Hi Emma/ Fiona,

Please be advised after review of the Modification to the Lindt Warehousing Facility in Marsden Park, I can confirm TransGrid has no objections to the proposed changes as it does not affect TransGrid's infrastructure.

TITLE
SITE / FLOOR PLAN

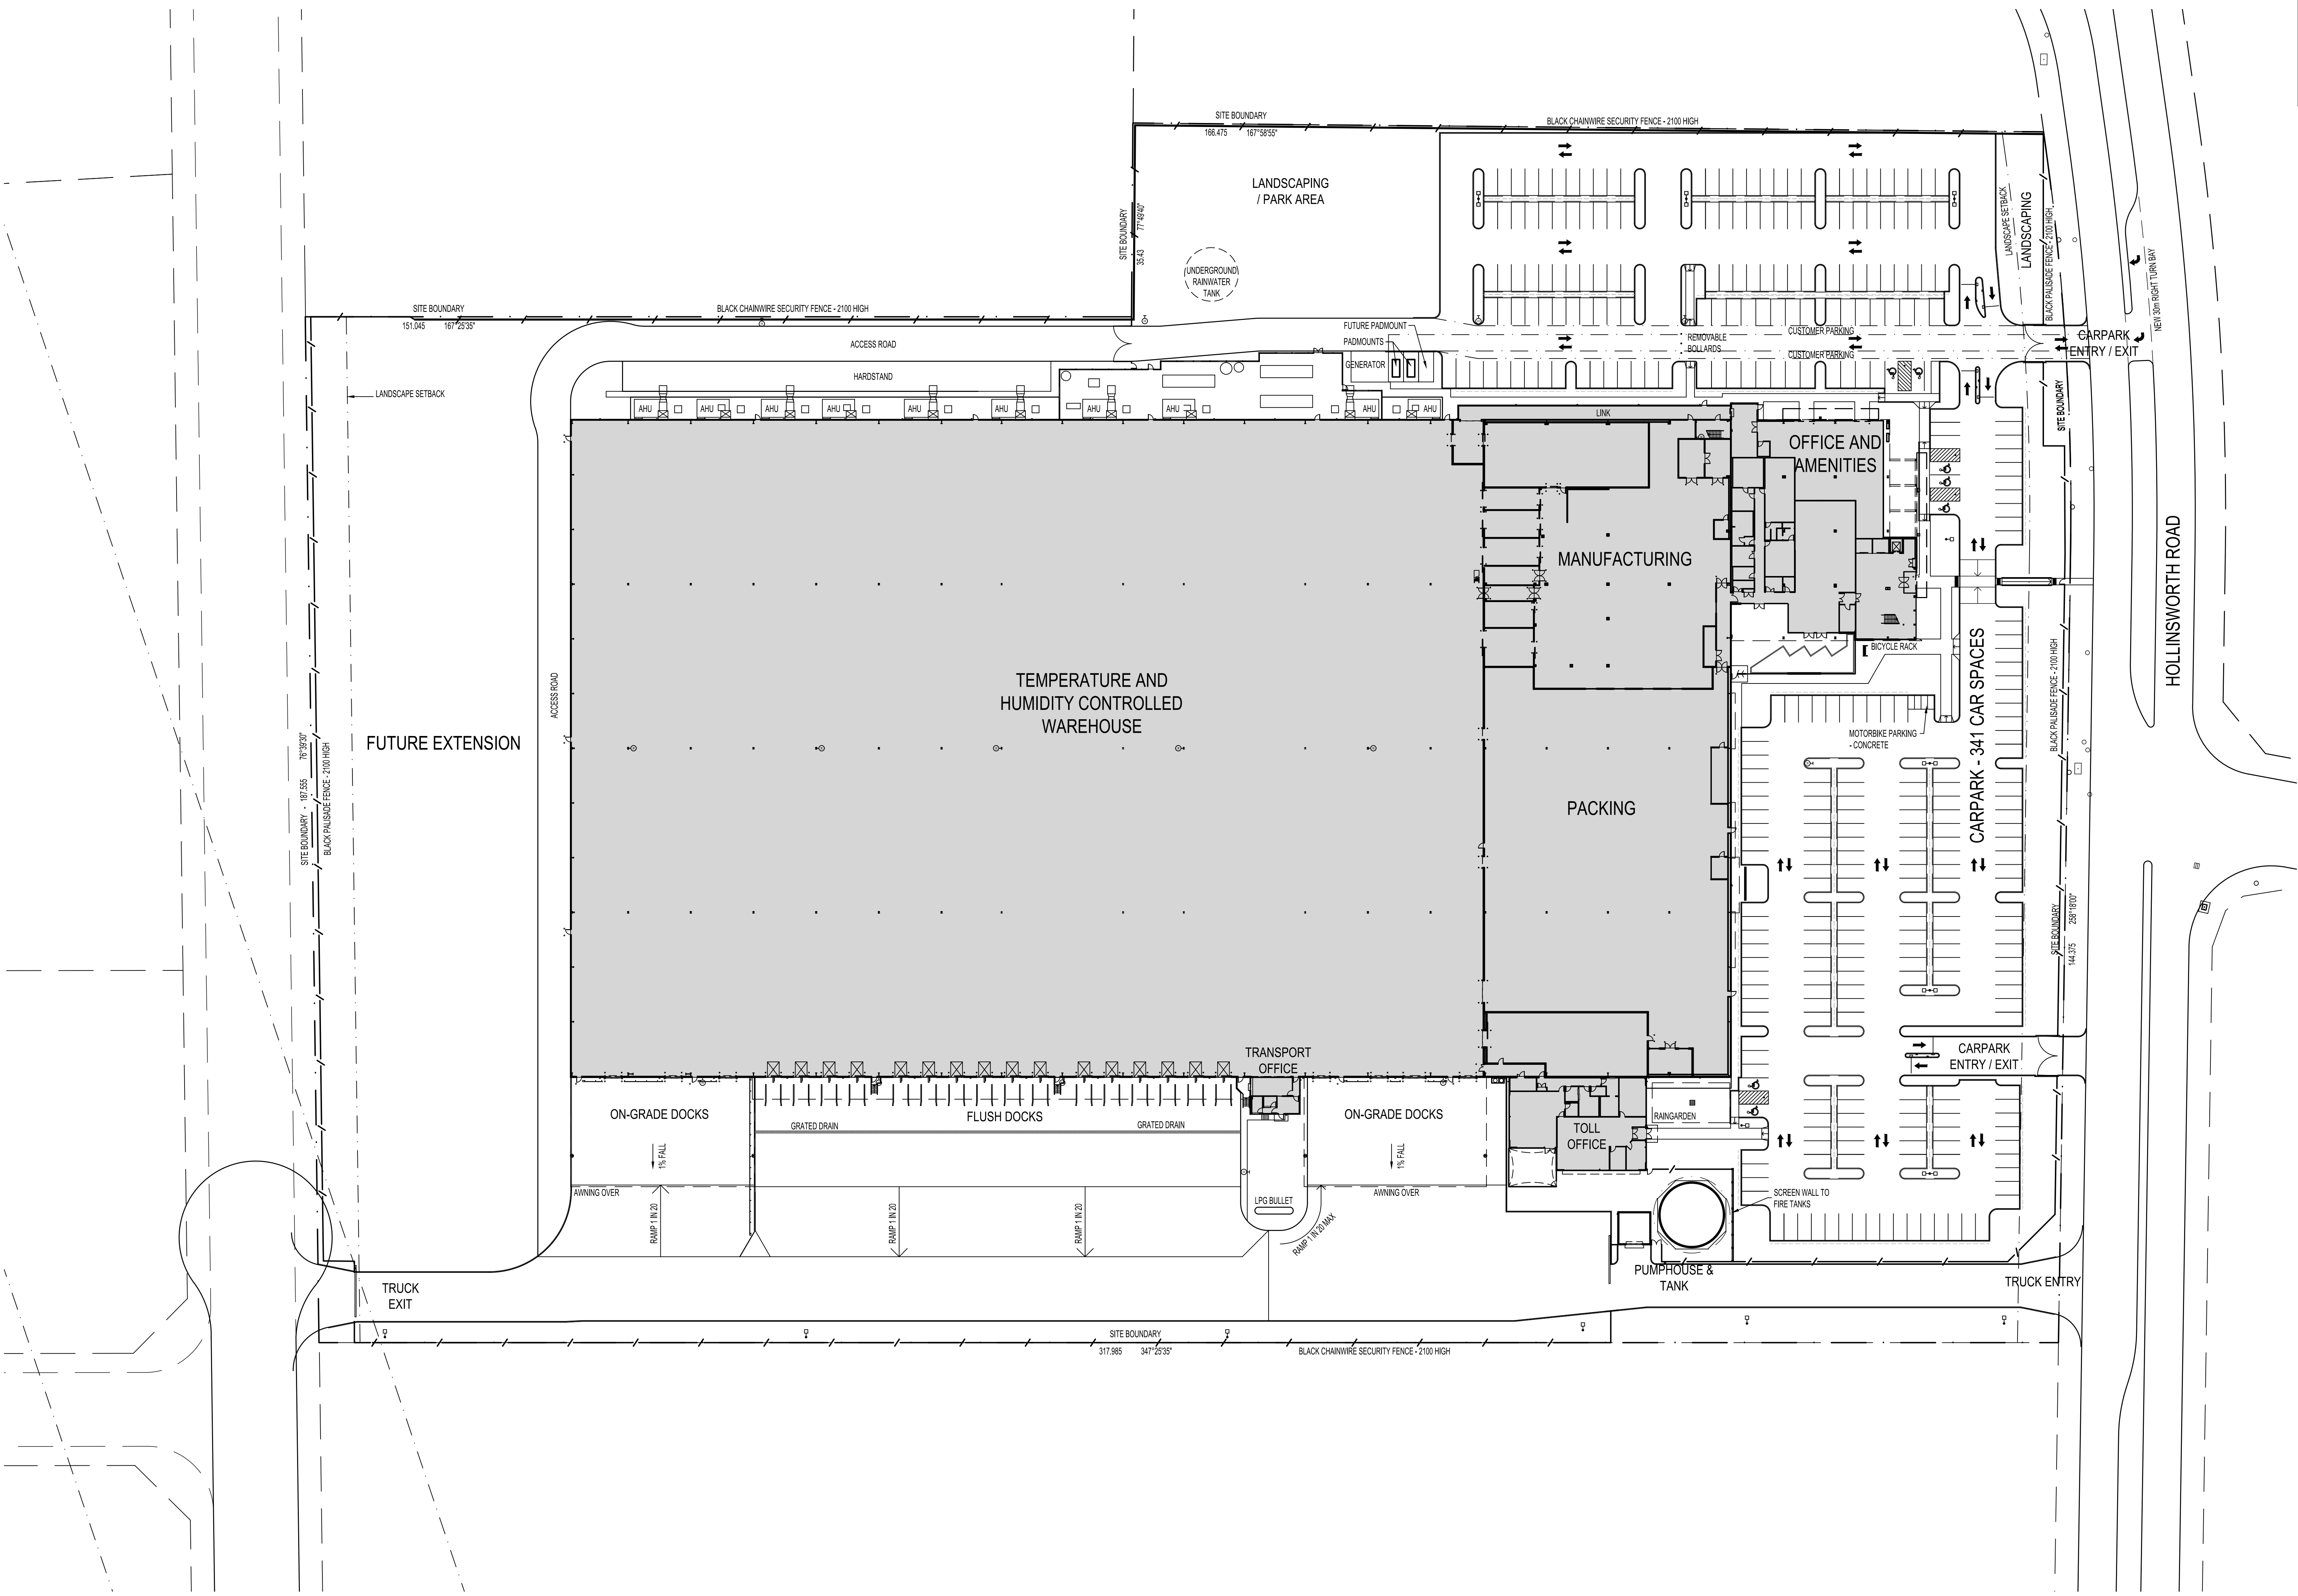
In regards to the 'truck exit' from the facility, the gates will need to be appropriately earthed as per TransGrid's Guidelines (attached). Regarding the proposed 'Future extension' at the front of the property, TransGrid requests notification of any proposed future development works.
